From: Nathan Green [REDACTED]
Sent: 12 September 2017 17:25
To: Anita Gardner
Subject: Re: A/112/17/CLP - Lawful Development certificate for single storey side and rear extension and loft conversion 11 Roman Avenue

6 East - Proposed
1 : 100

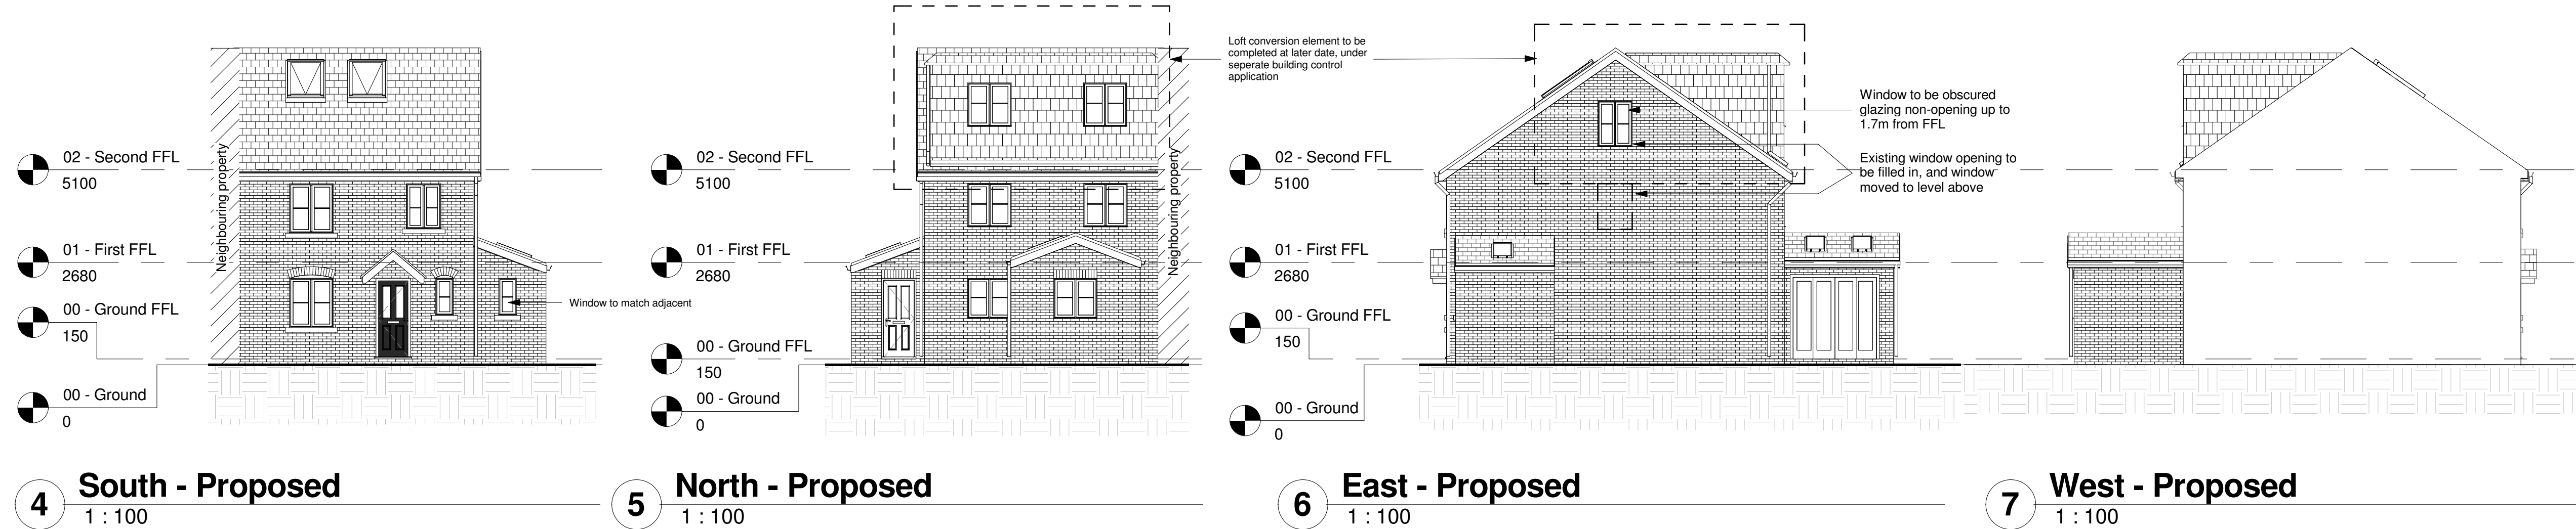
I mean the 2nd floor window in the east elevation serving the staircase

I refer to the above application and can advise that for the proposed window in the side elevation to be considered permitted development it must be obscure glazed and non-opening below 1.7m. There is no note to this effect on the plan and I would appreciate your confirmation accordingly

There was a note there originally, it must have been deleted when updating. Yes this window will be obscured non opening as mentioned.

1 Ground Floor Plan
1 : 50

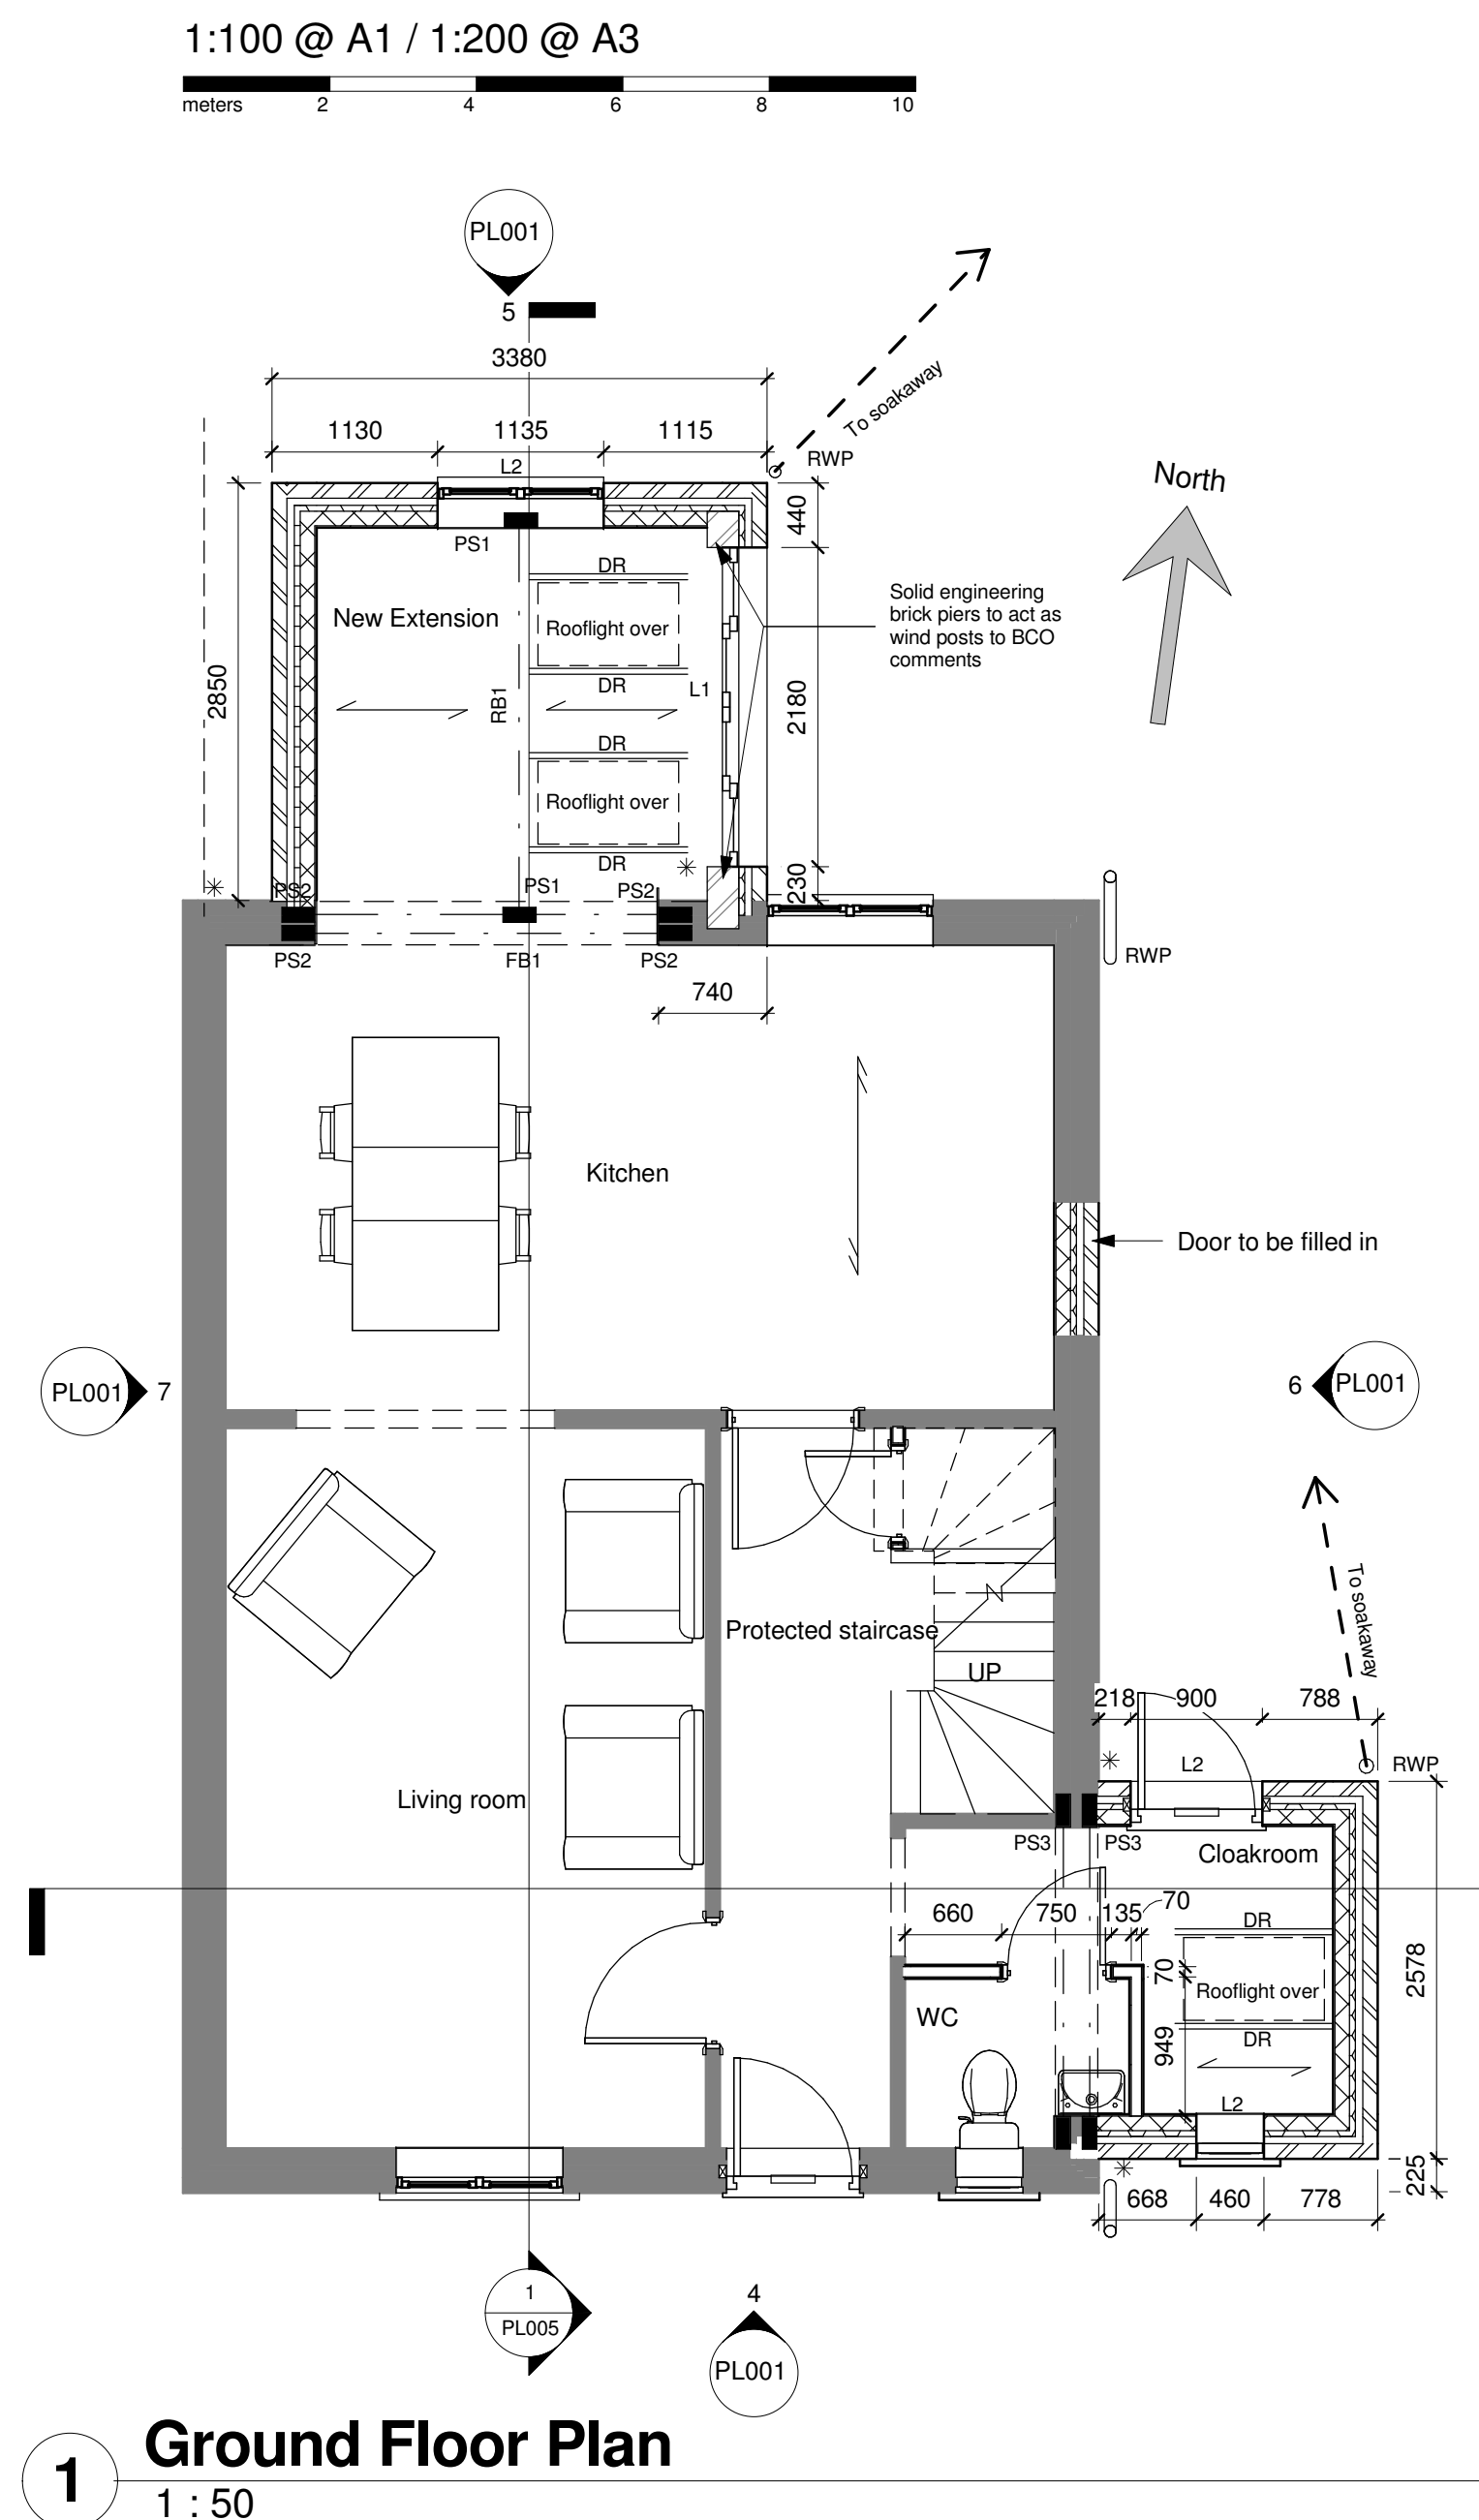
Yes the measurement I am referring to is 3.143m. The limit is 3m as per para 9h) (i) unless you are utilising the prior notification process

Further to our earlier correspondence the rear extension measures 3.1m and therefore exceeds the 3m limit. Do you want to amend with a substitute plan or do you want me to determine the application as submitted?

Please find attached updated plans with your comments incorporated, and thank you for clarifying.

Can I just check, is this the measurement in plan from the back of the existing house to the back edge of the new extension currently shown at 3143mm? I will of course submit a new plan as this measurement is now 2850mm.
